East Yorkshire Solar Farm
Limited

19 January 2024

Planning Act 2008 – Application for a Development Consent Order for East Yorkshire Solar Farm
Applicant Response to Section 51 Advice Letter Dated 19 December 2023
Application Ref: EN010143

TRAFFIC REGULATION MEASURES PLAN SHEET 14 OF 22

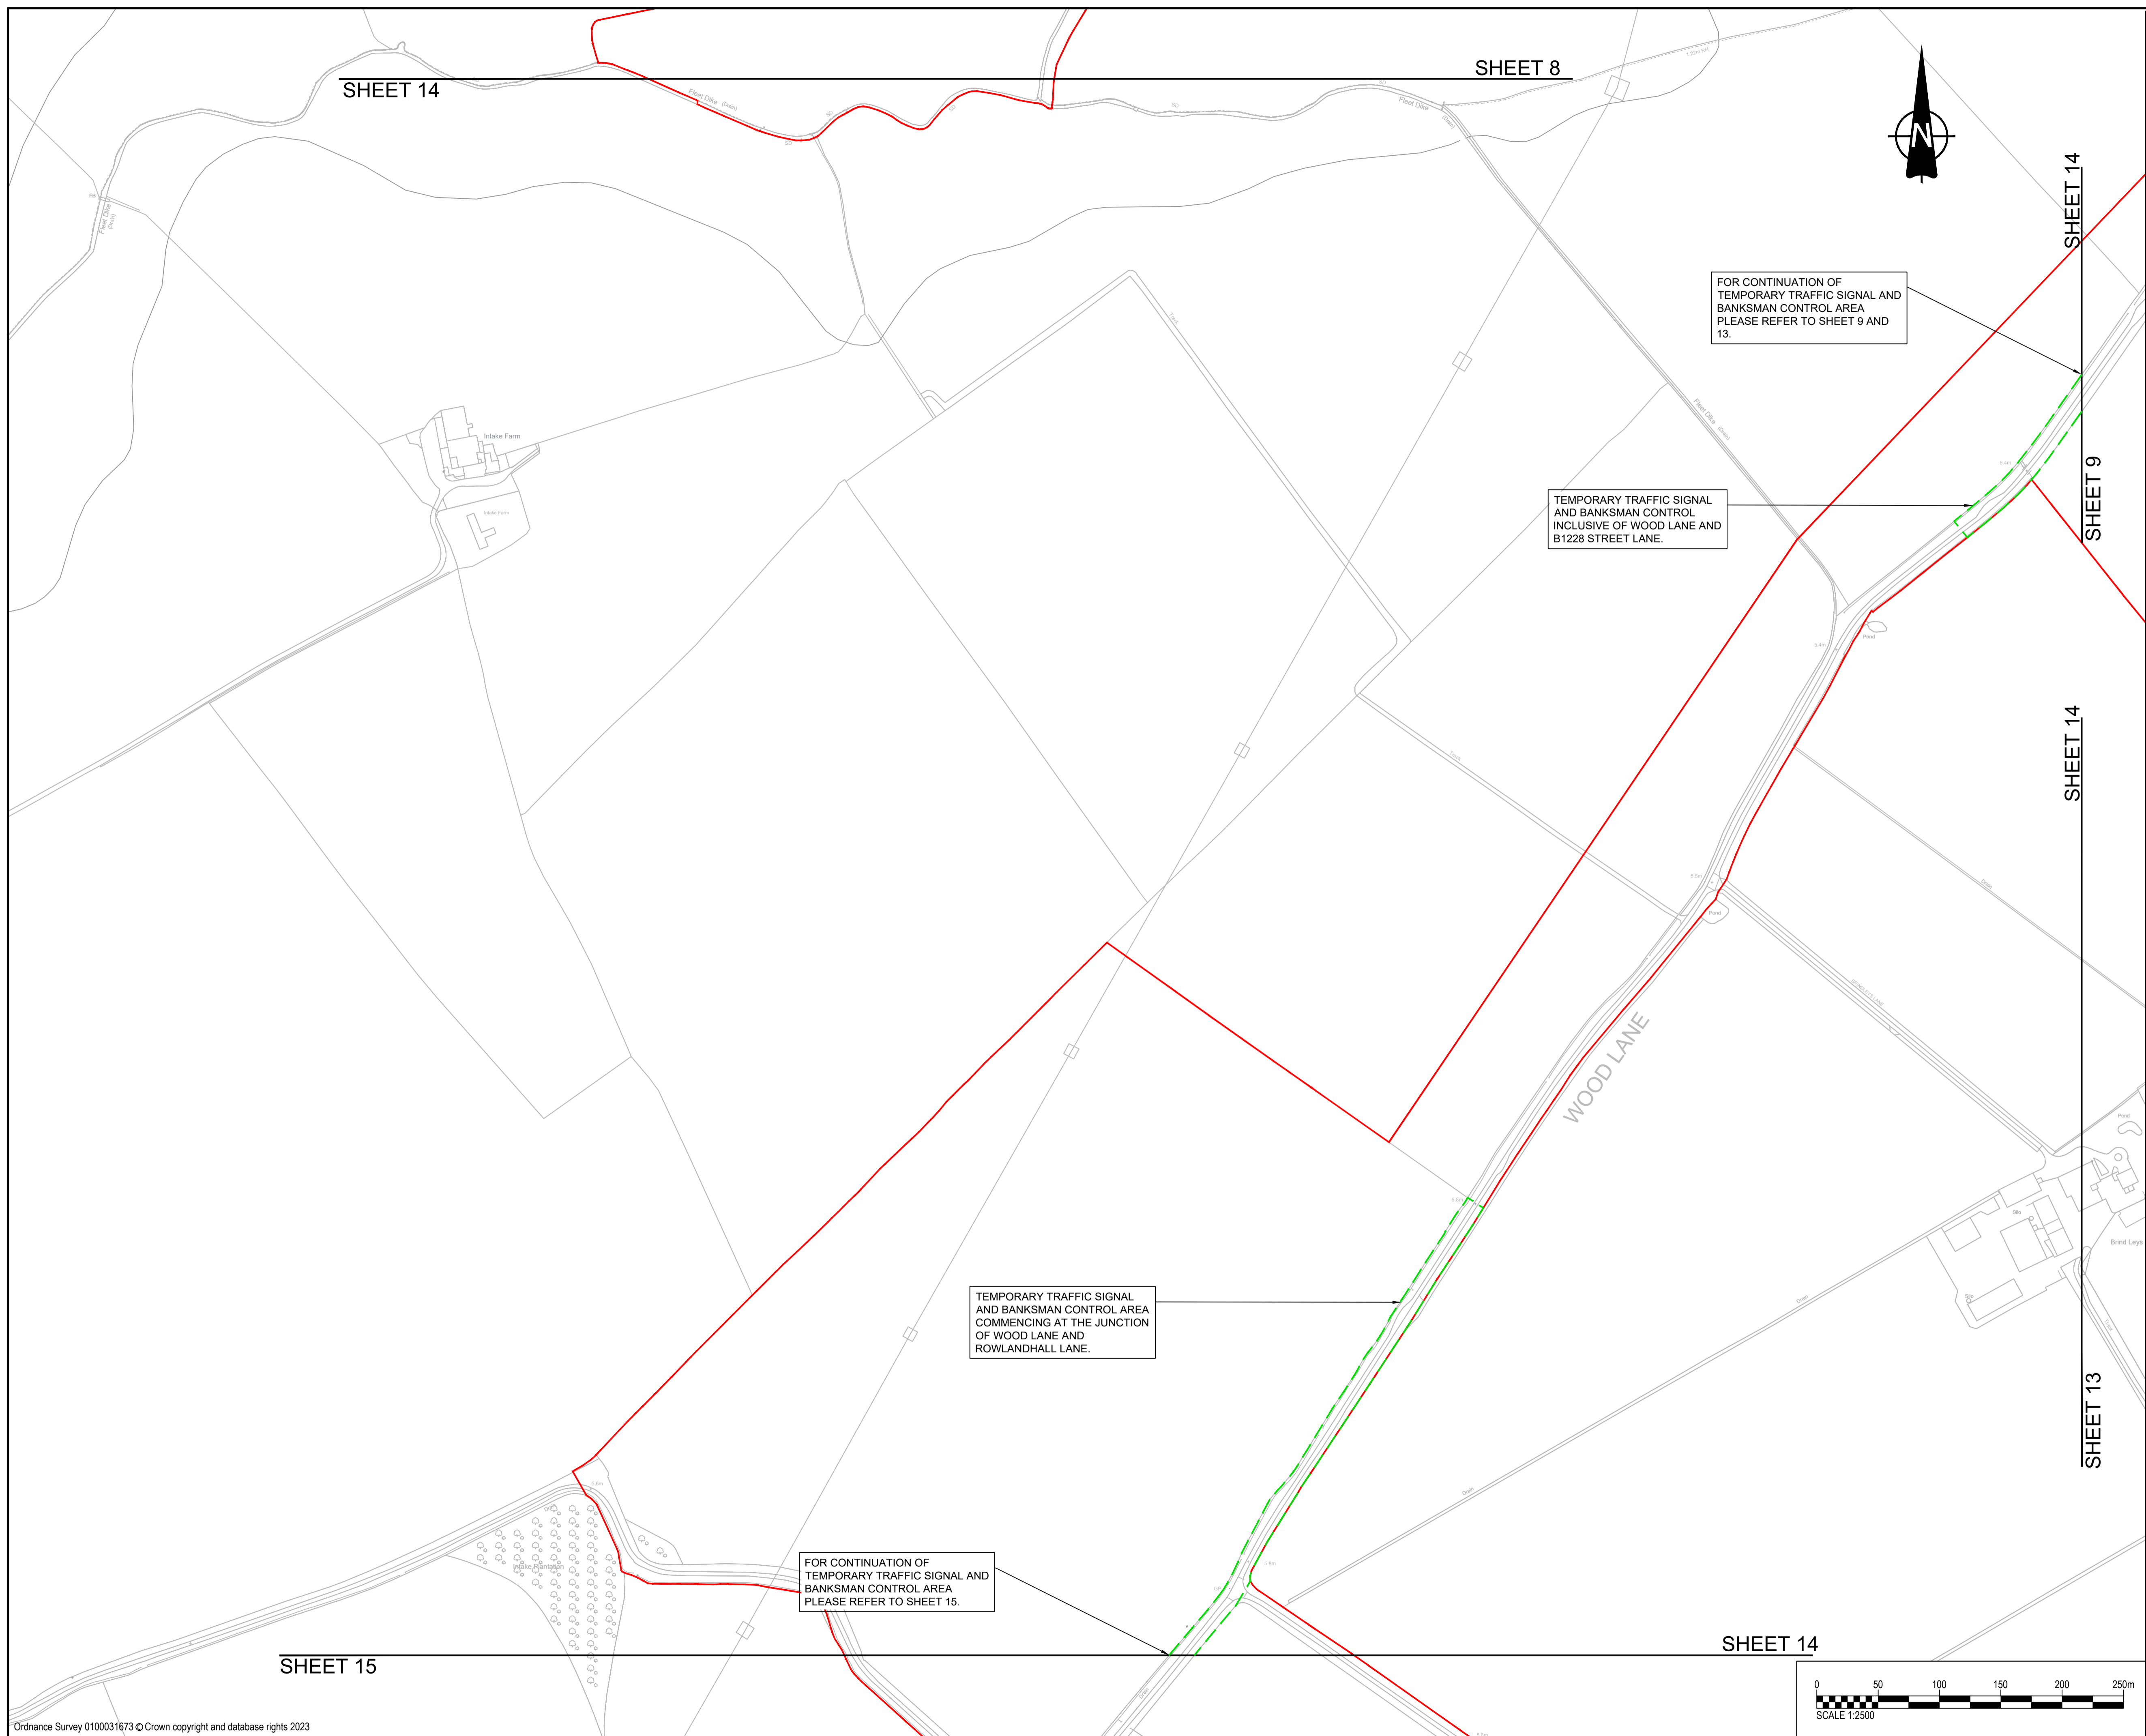
- 3.2. In respect of the specific advice, the labels within boxes on sheets 9, 13 and 14 showing 'B1228 Street Lane' twice have been updated and the repeated reference removed. Descriptions are now included for all temporary traffic signal and banksman control areas.
